Our Ref: PREAPP/23/00863

PROPOSAL: Proposed erection of a rear extension for form new kitchen, family room, downstairs disabled access toilet and utility room with upper floor new bedroom with attached shower room and new family bathroom

LOCATION: 38 Belle Vue Road, Shrewsbury, Shropshire, SY3 7LL.

OUTCOME: Amendments needed.

ELEVATION FACING 38
 BELLE VUE ROAD RETAINED

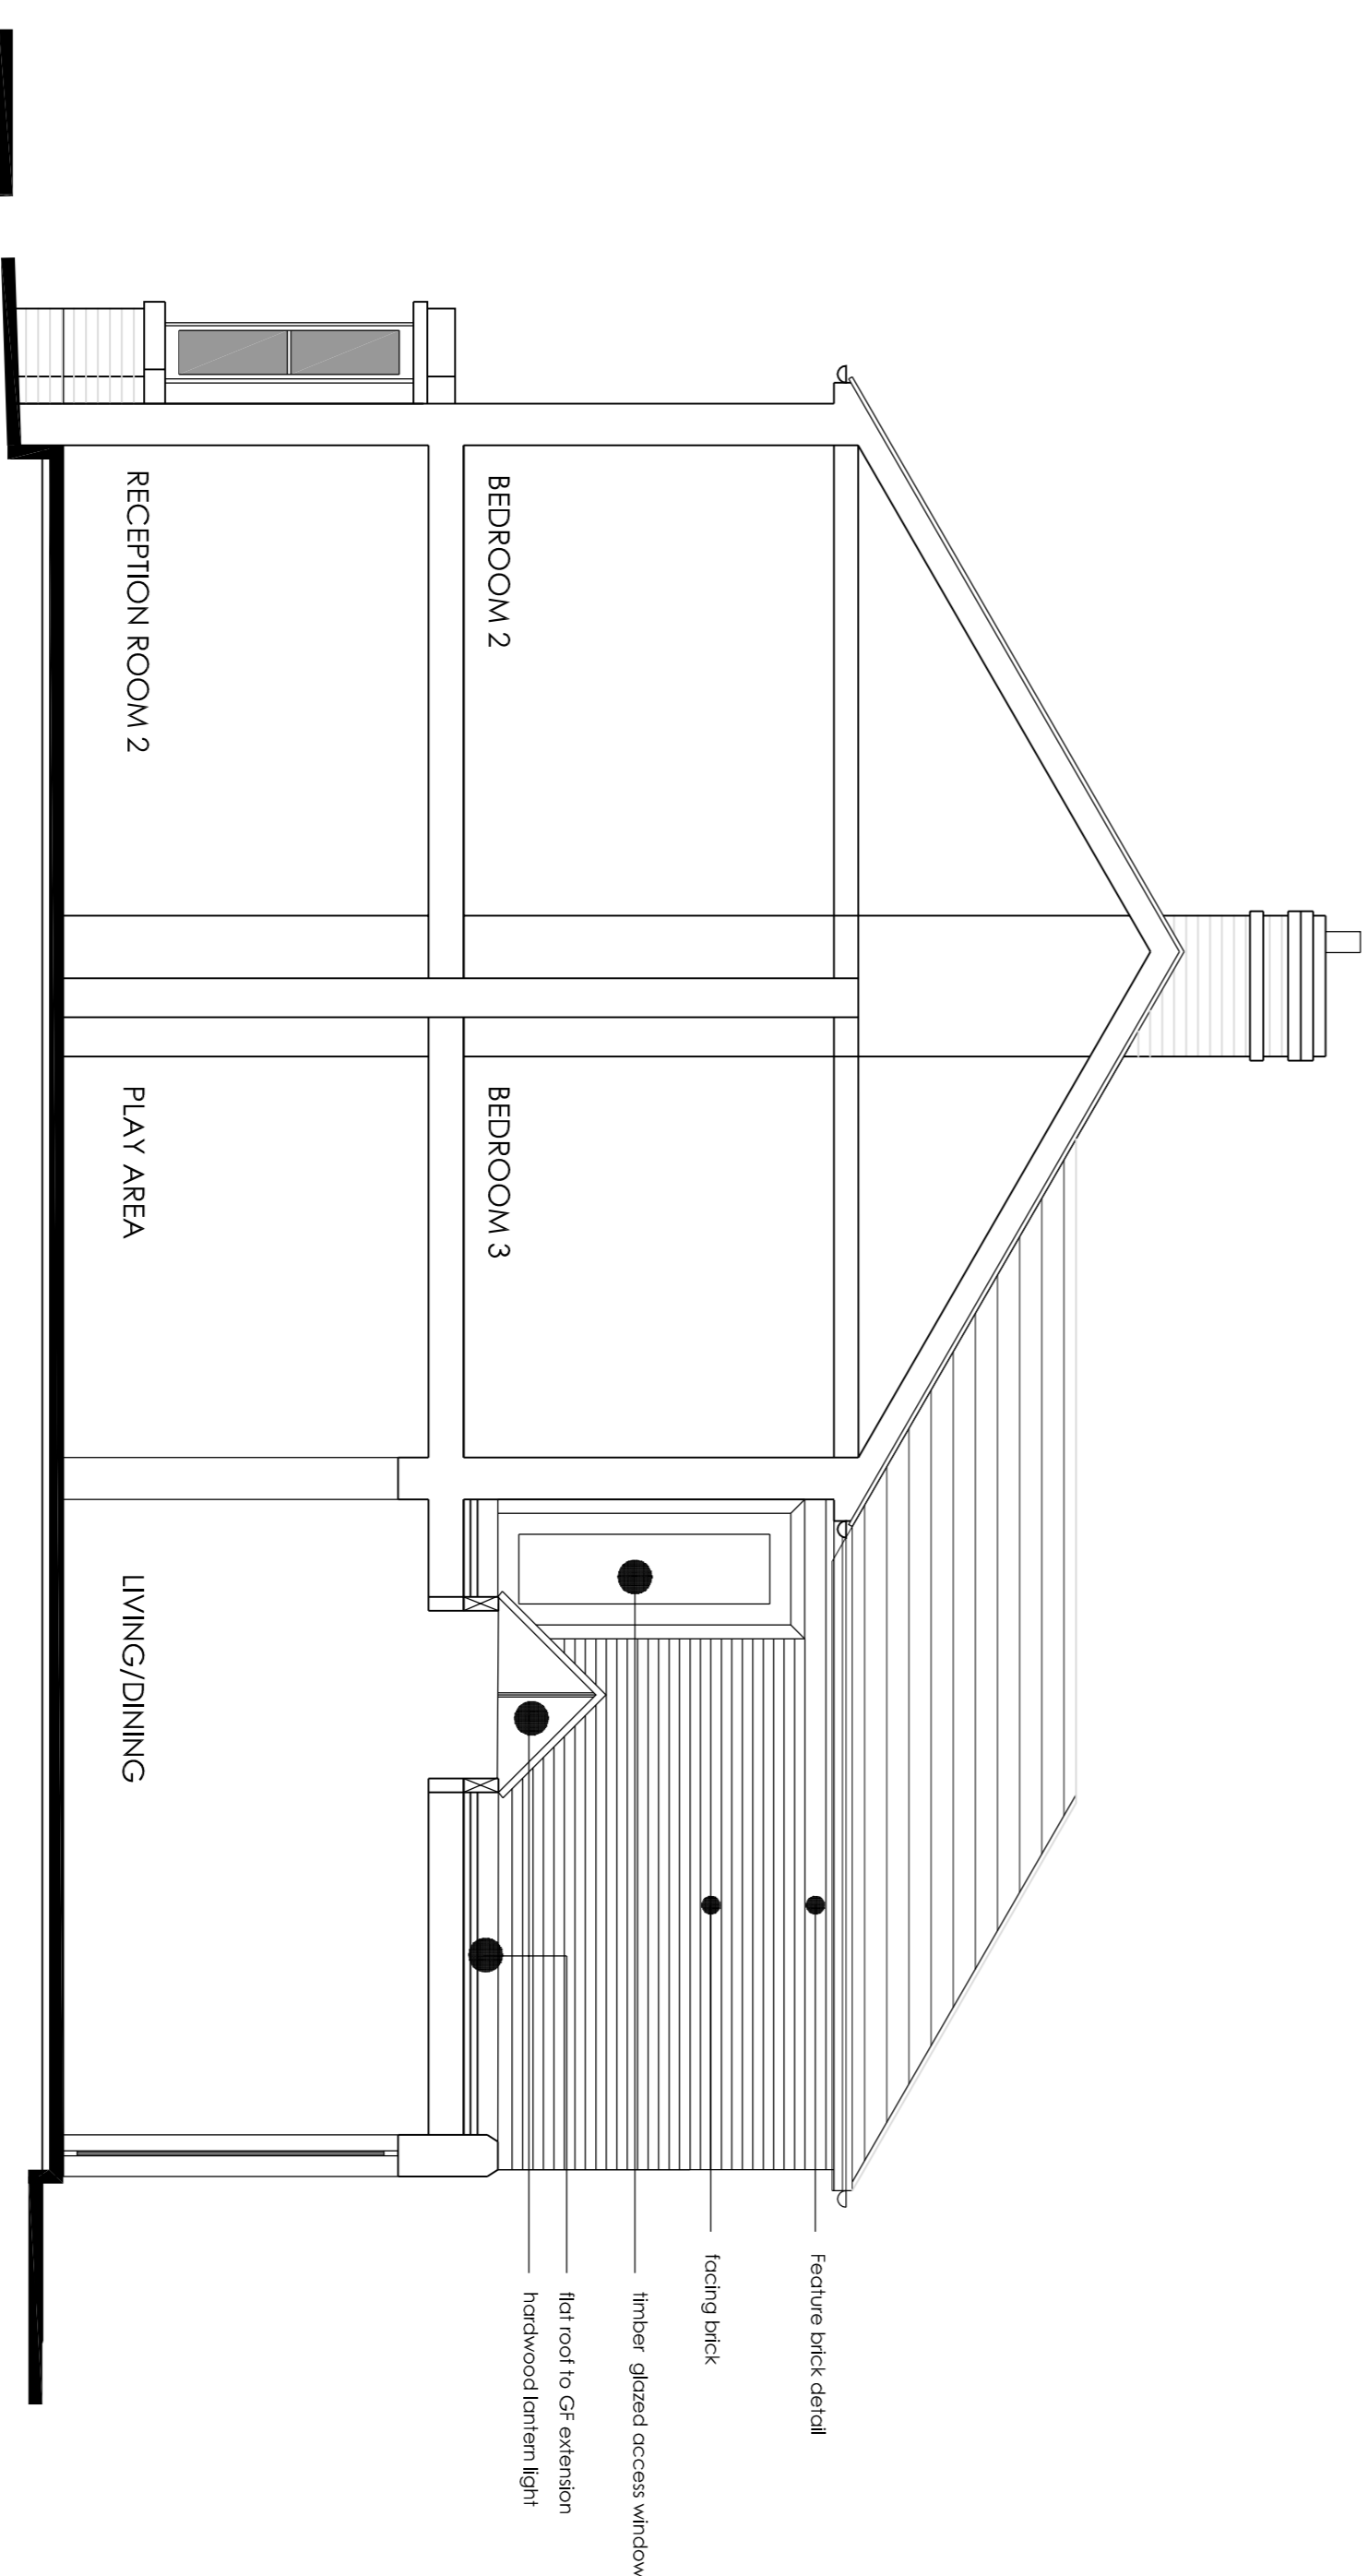
The principle of erecting two and single storey extensions to the rear of this dwelling is acceptable. However, I refer you to the comments below submitted by conservation team who recommend a reduced ridge height and inclusion of visual interest to the side elevation. On submission of a formal application, you will need to include a brief heritage impact assessment and in order to avoid conditions on the decision notice it would be beneficial to include details of external materials, joinery, windows and doors.

Generally, in this more traditional form and materiality we would not raise a heritage objection subject to agreeing final material samples. We do note that the side elevation facing the Church is quite tall as is the ridge height, and the side elevation wall a substantial area of unembellished brick, where dominant building forms should be avoided.
